Recommendation Report for Planning Permission for Works or Extension to a Dwelling

REF NO: EP/70/12/

LOCATION: Sandgate House
South Strand
East Preston Littlehampton

PROPOSAL: Alterations & first floor extension, providing a reduced garden room on the ground floor, together with conversion of garage to a gym & 2 new bedrooms, study & bathroom to first floor. Removal of existing pitched roof & replace with lower mono pitched roof

1207 SK26
 Sandgate House, East Preston
 Elevations As Proposed - sheet 2
 June 2012
 scale: 1:100

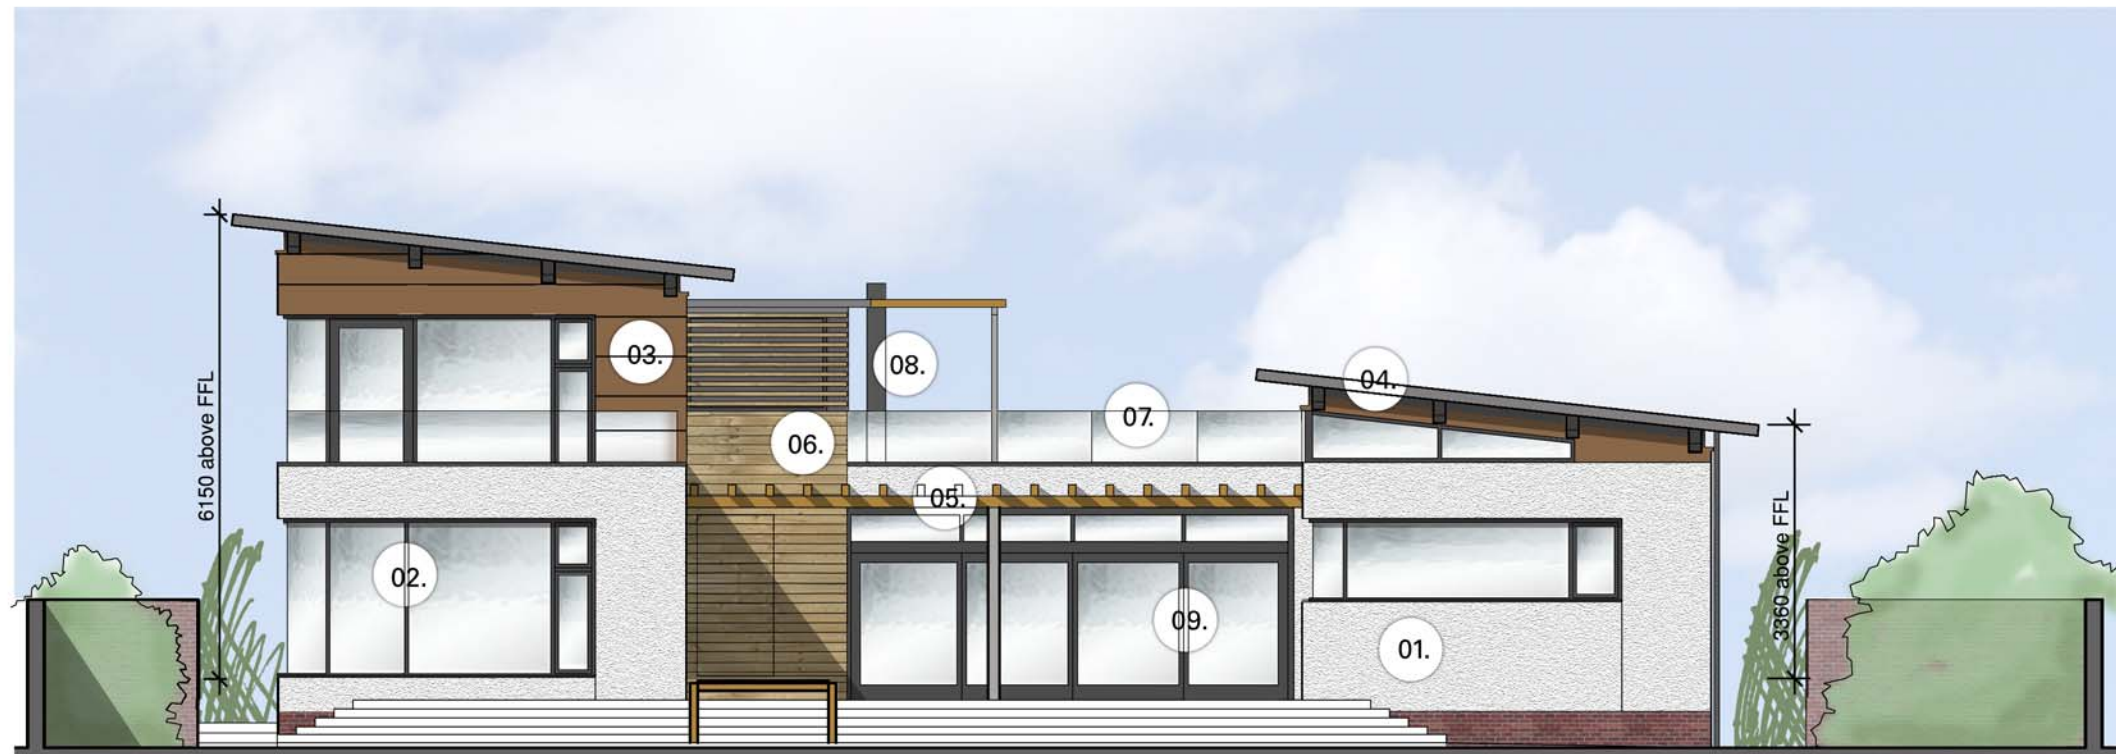
The property overlooks the beach, accessed via a private driveway from South Strand. It is not visible from the highway to the north, however its southern elevation and roof slopes are readily visible from the beach. The property was constructed in the 70's and does not appear to have been updated since it was originally constructed. Its design is not considered to be of any significant merit and therefore the alterations in principle are considered to be acceptable.

The proposed design of the additions would significantly alter the appearance of the dwelling, and the addition of a second storey would mean that the extensions would fail to meet criteria set out for extensions of residential properties in Local plan policy DEV19. The proposed additions and alterations would give the property a contemporary appearance which is not something that is noted within the immediate vicinity. That being said, the NPPF together with the East Preston

Design Statement both support the inclusion of innovative and original design. It is considered that the properties within the locality vary significantly in both design and scale. This means that whilst the proposal would conflict with parts of policy DEV19, the proposed contemporary design and distinctive mono-pitch roof design would be acceptable from a visual point of view, and would not unacceptably detract from the locality.

1207 SK25 A
Sandgate House, East Preston
Elevations As Proposed - sheet 1
June 2012
scale: 1:100

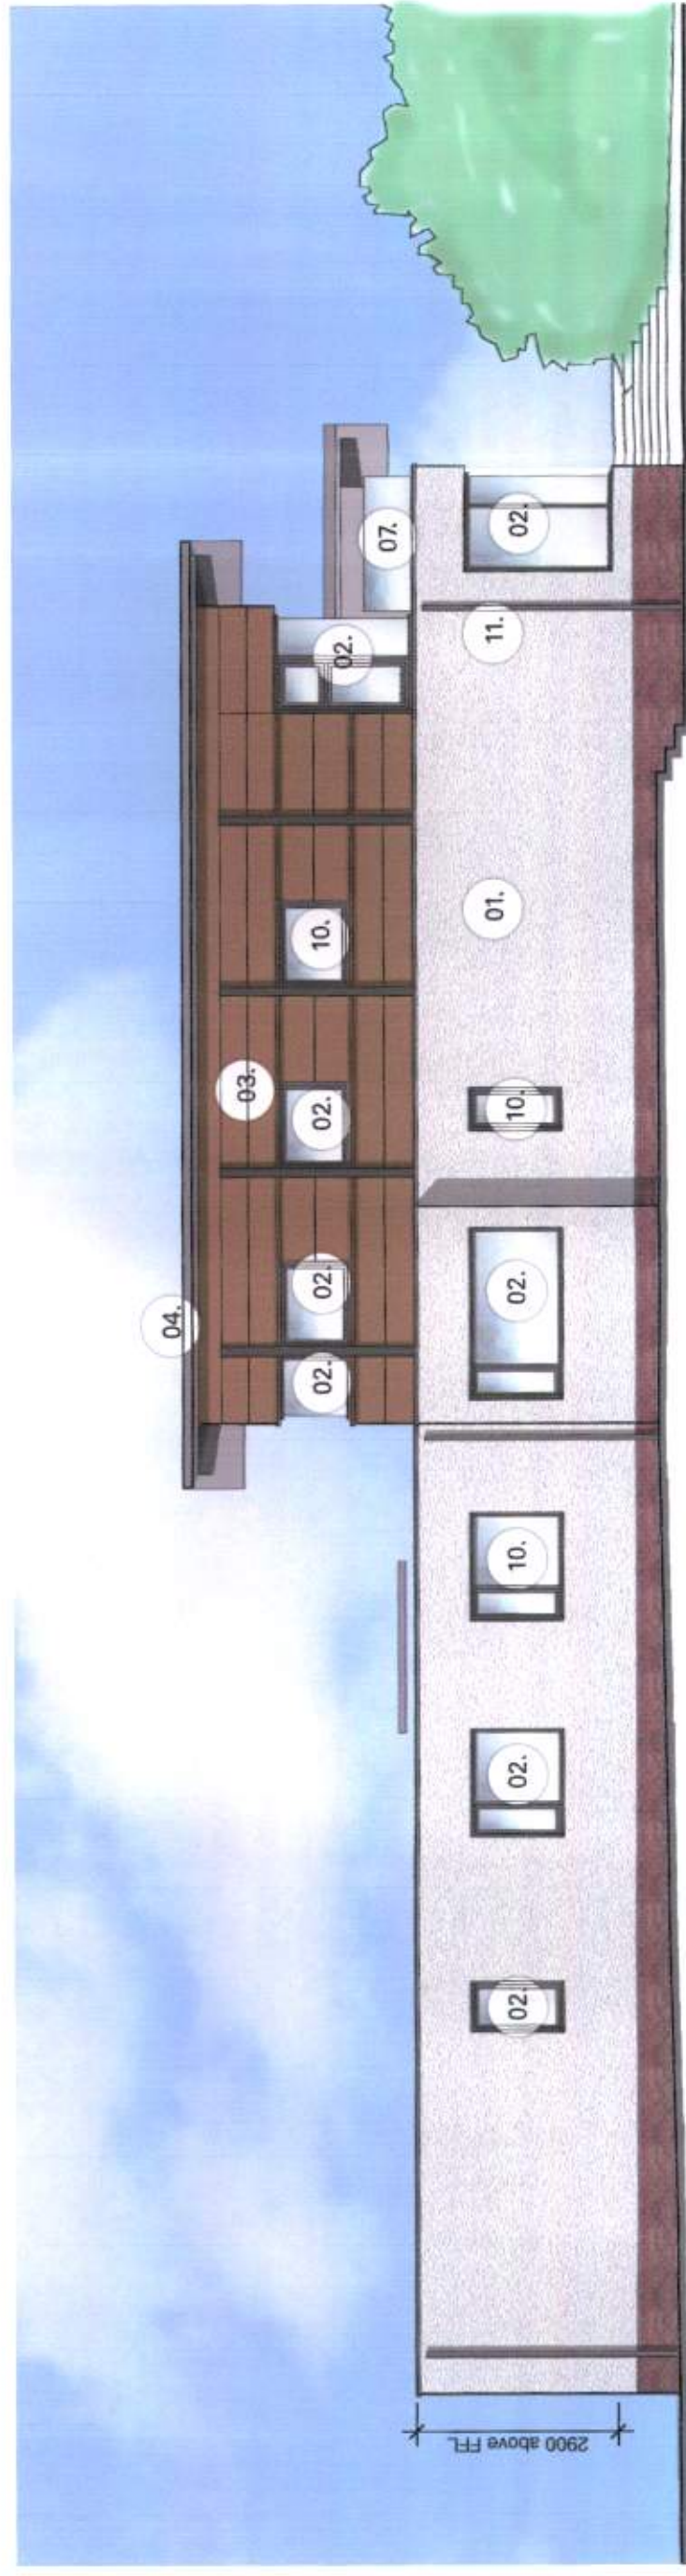
The impact from first floor windows facing north and south are also acceptable due to separation distances to neighbouring properties, and a condition ensuring that all windows to the west elevation at first floor level be obscure glazed, restricts any views directly towards the neighbouring garden or dwelling. The proposed balcony and deck areas would overlook the beach and given the openness of adjacent gardens, would not result in any unacceptable overlooking of neighbouring sites. Suitable screening will however be required for the balcony and deck areas to restrict any direct views to neighbouring sites. Subject to the conditions suggested the changes would not result in any direct or unacceptable levels of overlooking of neighbouring sites.
